BCA Compliance Report (prepared by BCA Logic)

Project: **NSW POLICE FORCE, POTTS HILL
BUSINESS PARK**

Report: **BCA ASSESSMENT REPORT**

Date: 29th October 2008

E1/1 BUILDING 1 - EAST ELEVATION 1:200

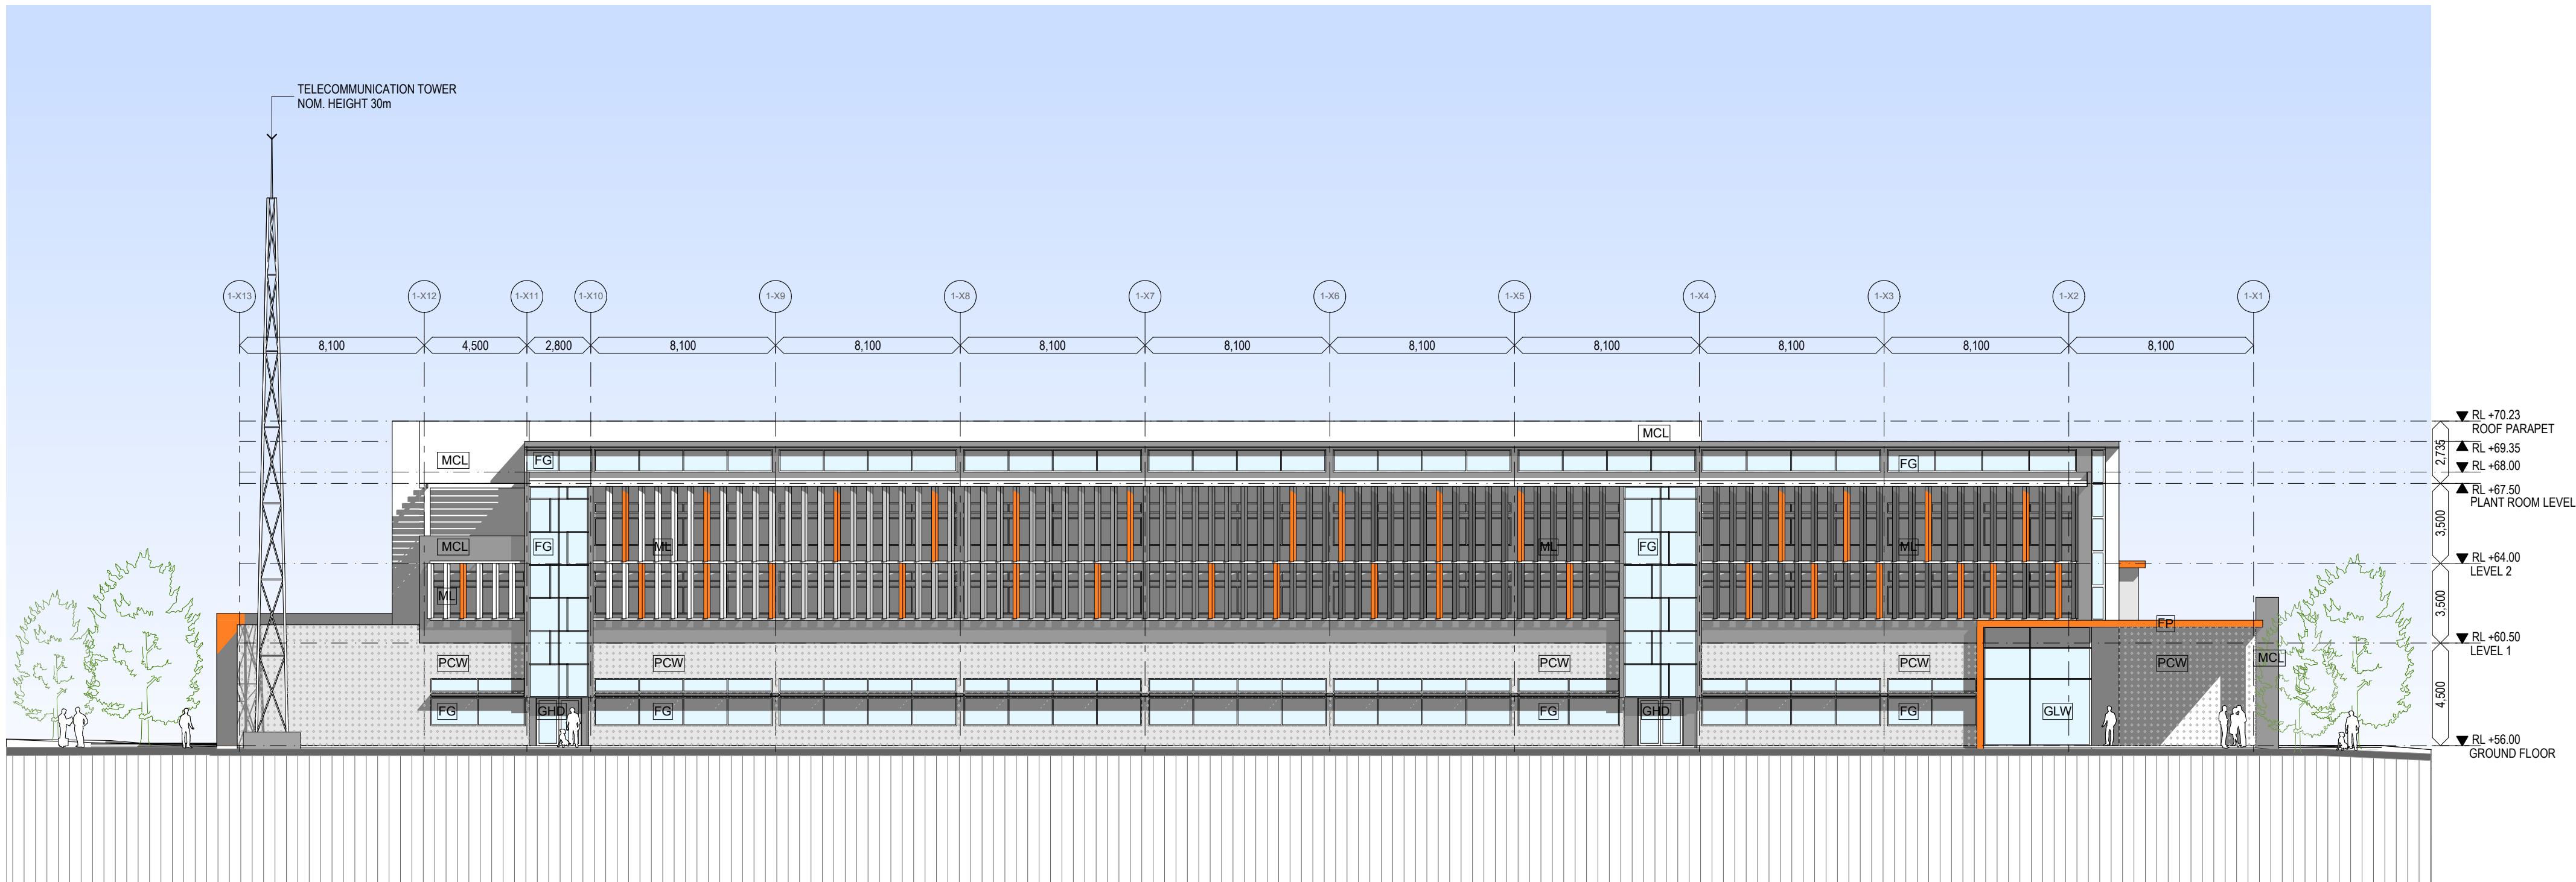
5. Internal wall wetting drenchers will need to be provided over fixed glazing where the path of travel from the eastern FIS's to Building 1 involves passing within 6.0m of openings at ground level as required by D1.7 and C3.4 of BCA2008.

- The only FIS's required are those to Building 1 and 2. The FIS's that discharge along the eastern side of building 1 will involve persons walking past openings in the same building within 6.0m. As such protection of these openings will be necessary with internal wall wetting drenchers over fixed glazing.
